CITY OF ALBUQUERQUE

RE: Fast Food Restaurant
Grading and Drainage Plan
Engineer's Stamp Date 4-7-2017 (File: B14D001)

C1

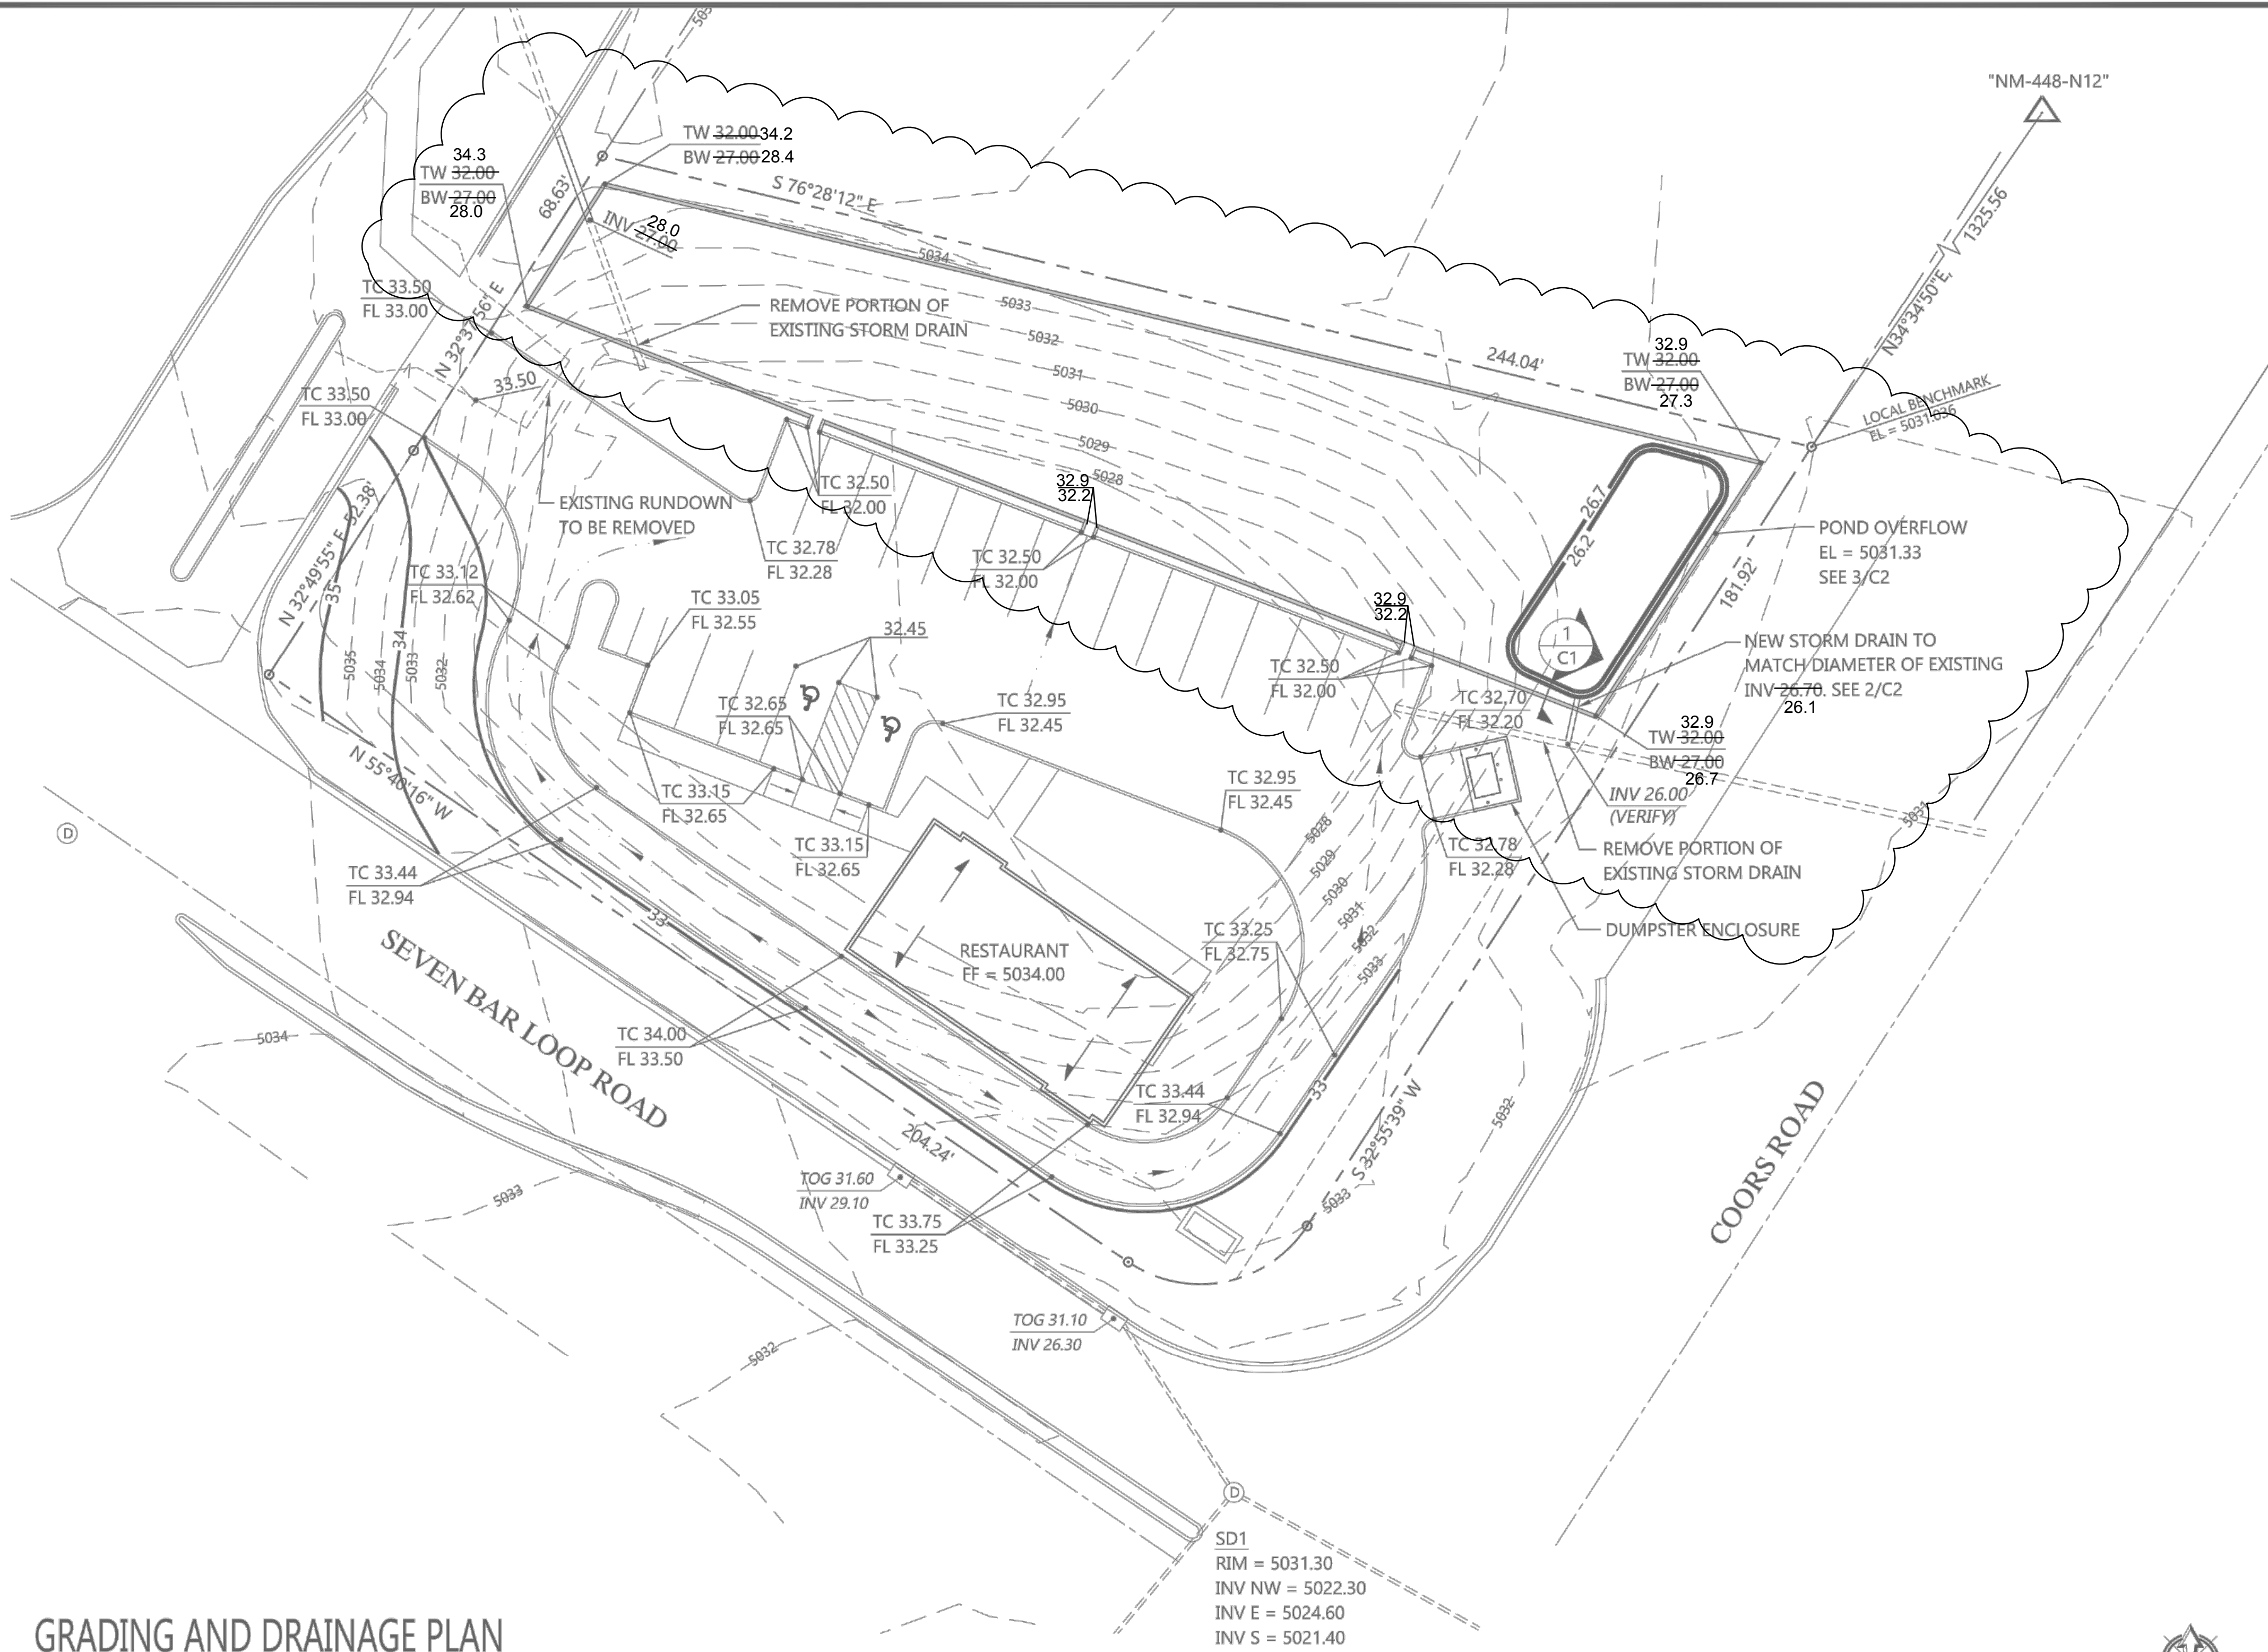
1. Provide size for the existing storm drain on the west side of the site.
2. Provide calculation for emergency overflow.
3. Provide more spot elevations along the curb and between curb cut on the south side of the pond.
4. Are sidewalk culverts being proposed at the same down spots? Roof flows should not discharge directly onto the sidewalk.
5. Provide details for the trash enclosure to ensure runoff will remain within the enclosure. Included a note that the drain must be connected to a Grease Trap then to the sewer system. Show the location of the Grease Trap and the inverts for the pipe.
